Toby Philp - FW: Landscape and Visual Impact Assessment

RE : Objection - Yass Valley Wind Farm proposal Application Number: MP08_0246

Yass Valley Wind Farm – Submissions Report
Landscape and Visual Impact Assessment
For: Yass Valley Wind Farm Pty. Ltd
0092376 RPT2 Final
December 2012

Figure 1-5 Wind turbine location changes - Coppabella precinct

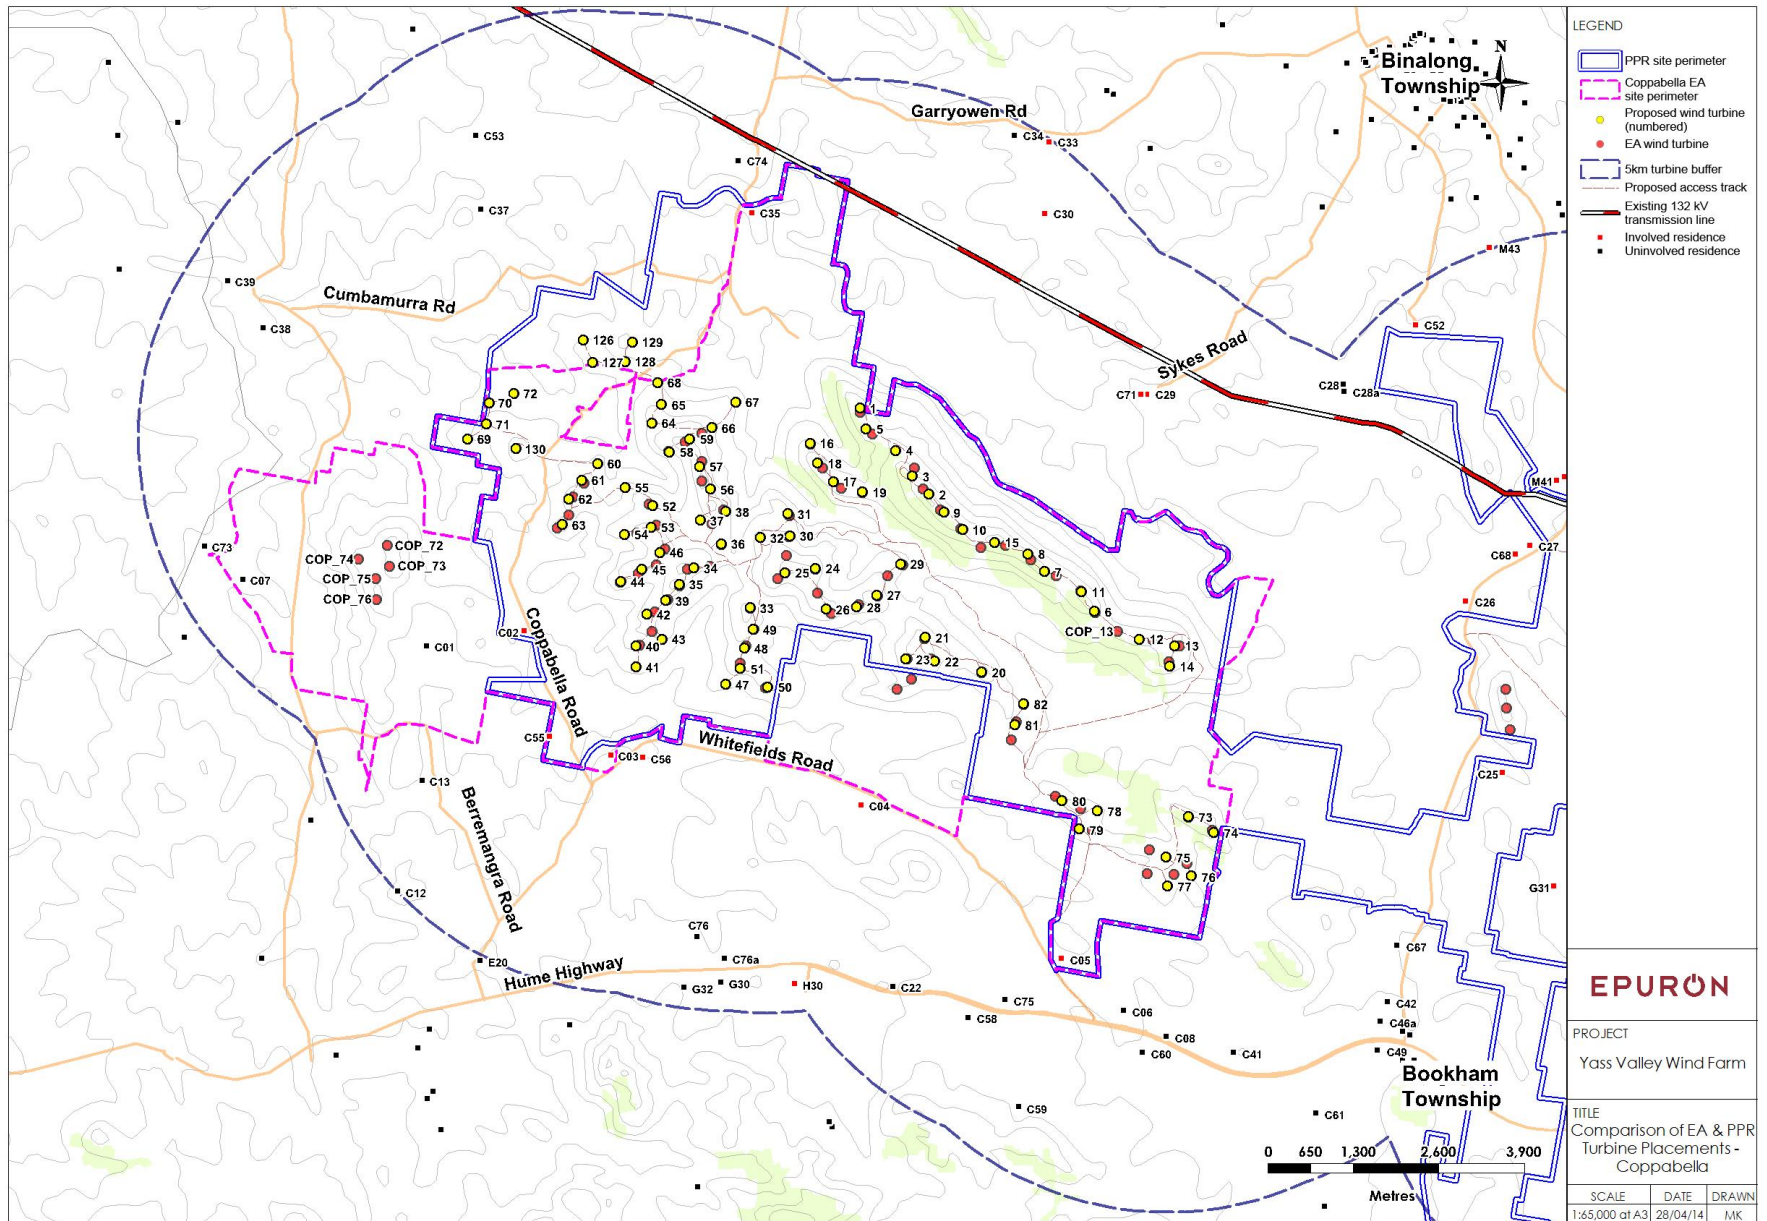
Issue	Details	Clarification Requested of Epuron
Impacted Residences	Figure 1-5 of the PPR is missing a residence that was constructed in 2012. This residence is within 1.5km of a proposed wind turbine and is therefore well within the zone of impacts from both a noise and visual impact perspective (as outlined in the 2012 EPA Infrasound Report and the 2009 Environmental Assessment). Figure 1-5 of the PPR is also scaled to exclude a number of fringing residences that are within 1.5km – 2km of the proposed turbines and therefore should be included as potentially impacted residences.	Amend the PPR to accurately reflect the residences in the area, and amend the impact assessment to include these residences. Update the stakeholder engagement to include a targeted assessment of all impacted residences.
Community Consultation	Section 3.6 of the PPR indicates that “Epuron has contacted and continues to consult with the neighbouring landowners”. This is not an accurate reflection of the number of landowners who have been consulted with. Epuron’s community engagement to date has been selective, and has not included a number of residences that are within 2km of the proposed residence site (including those of my parents-in-law and my brother-in-law) (as required by the Director General’s Requirements dated 2009). These residents will be impacted both by low frequency noise and visual amenity changes, but have yet to be consulted. A number of residents have expressed feelings of discontent and powerlessness regarding the lack of formal engagement.	Engage in all non-involved and involved landowners in a systematic and inclusive manner, particularly those whose residences are within 2km of the proposed wind turbine locations.
